UDON, PPR-24-22 2nd Revision

Please accept the following comments from El Paso County Public Health for the plot plan review request referenced above:

POND PLAN
 SHEET 9 OF 20

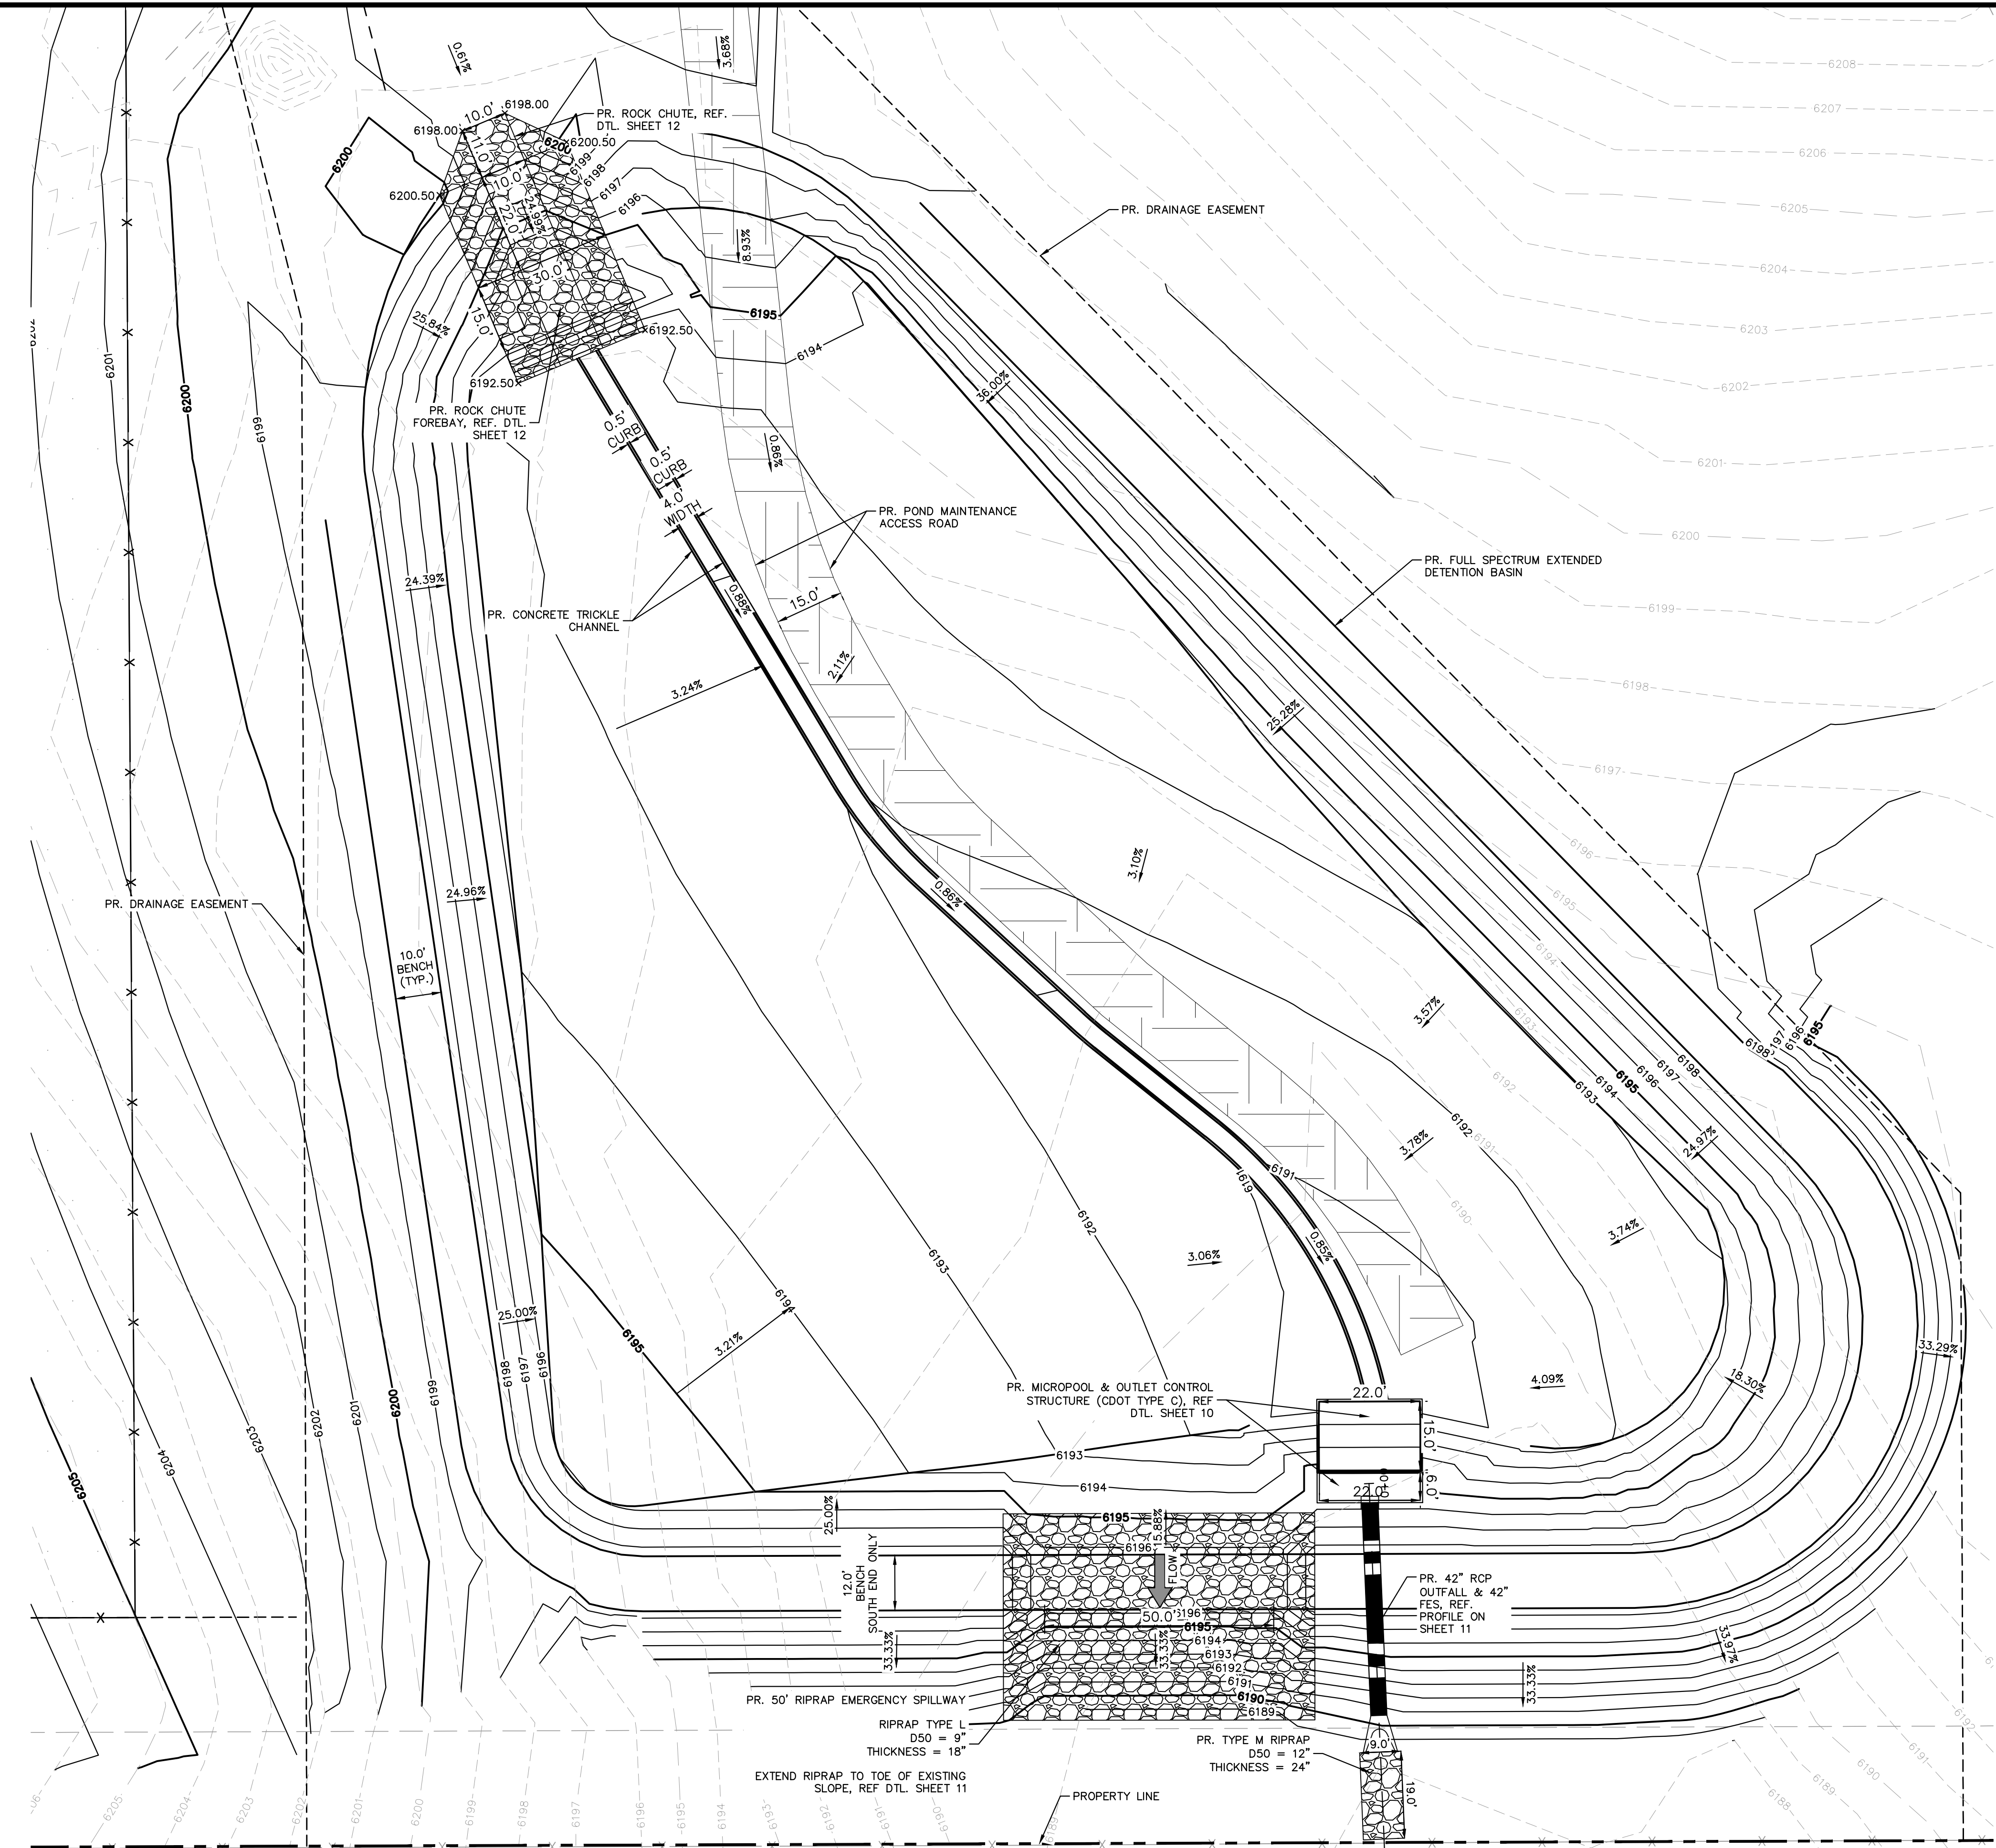
- The water quality basin must have mosquito control responsibilities included as a part of the construction design and maintenance plan to help control mosquito breeding habitat and minimize the potential for West Nile Virus.
